KITTITAS COUNTY

December 20, 2016

County Survey review of Boundary Line Adjustment 16-00011 (Patty / Bradshaw)

SHEET 1 OF 3

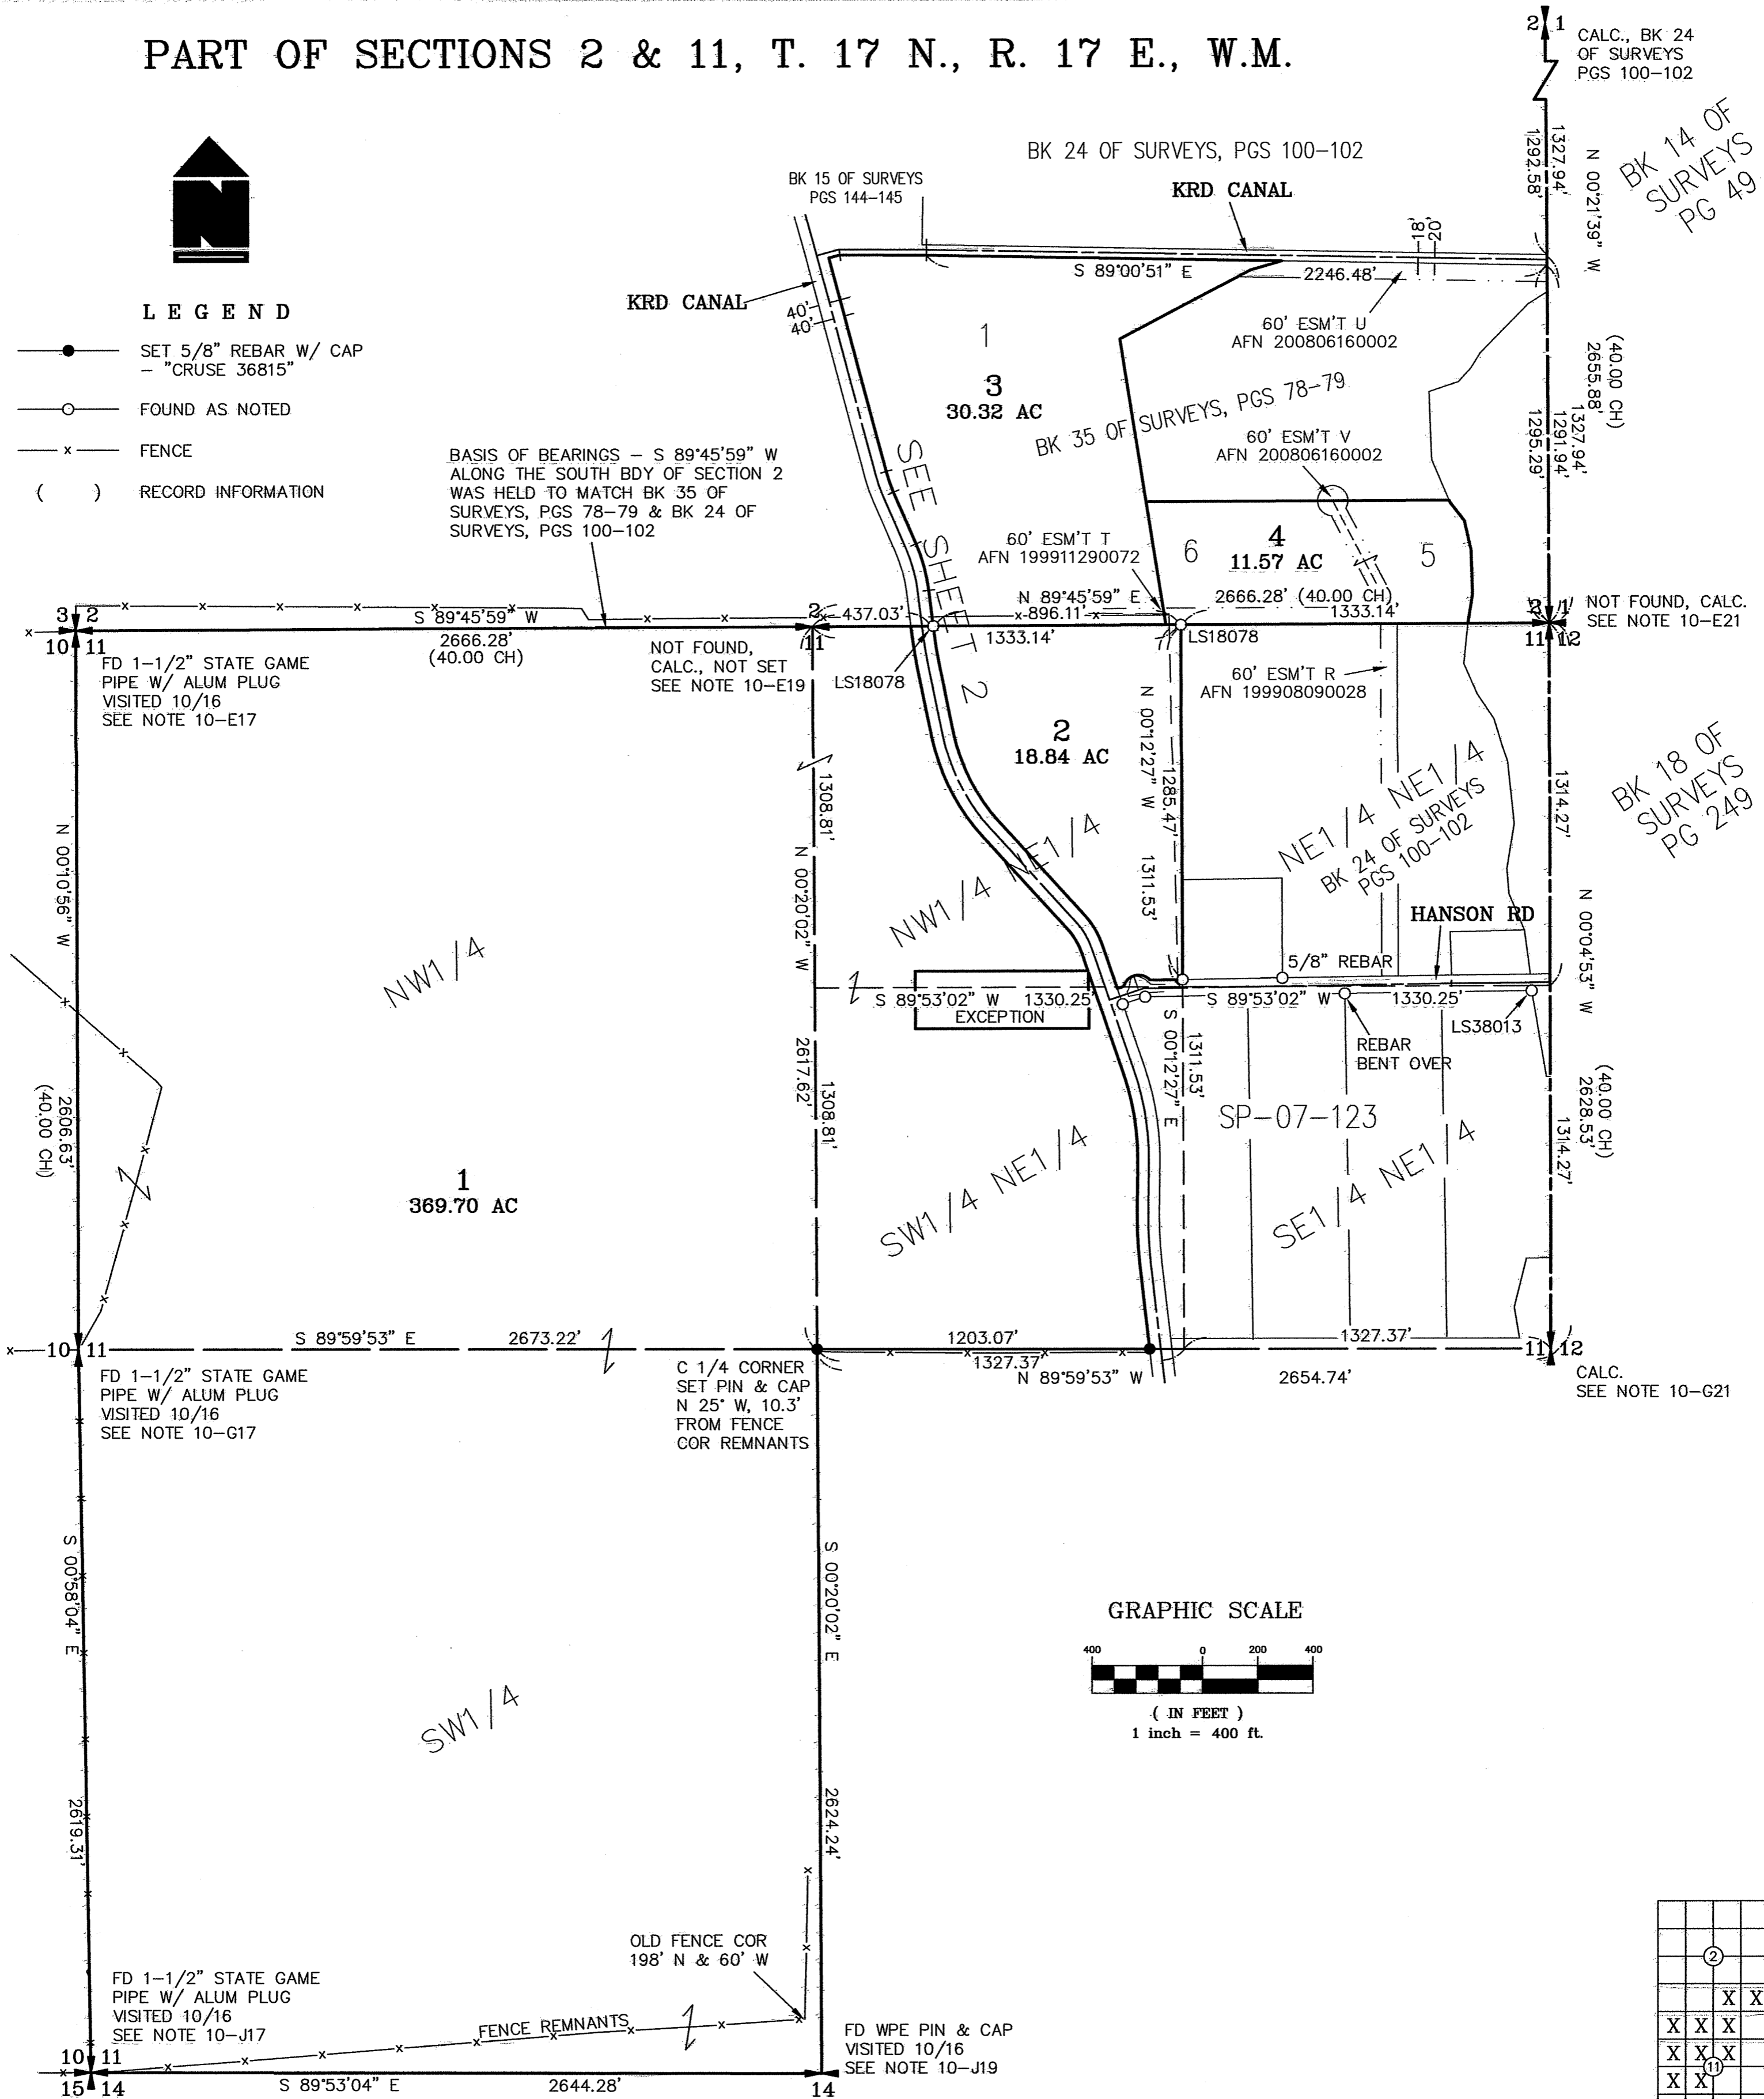
1. A reference note stating the purpose of the survey with the application number shall be added. (KCC 16.10.020(1))
2. Easements shall list the purpose (access, utility, etc.). It appears that AFN:200806160002 is non-specific in its purpose,
3. The dimension near the NE corner of Lot 3 should be arrowed in, or rotated to make it clear as to what it is dimensioning.
4. Please graphically show the usage line and access area for the area shown as "exception" to Lot 1. (WAC332-130-050(1)(f)(vii))
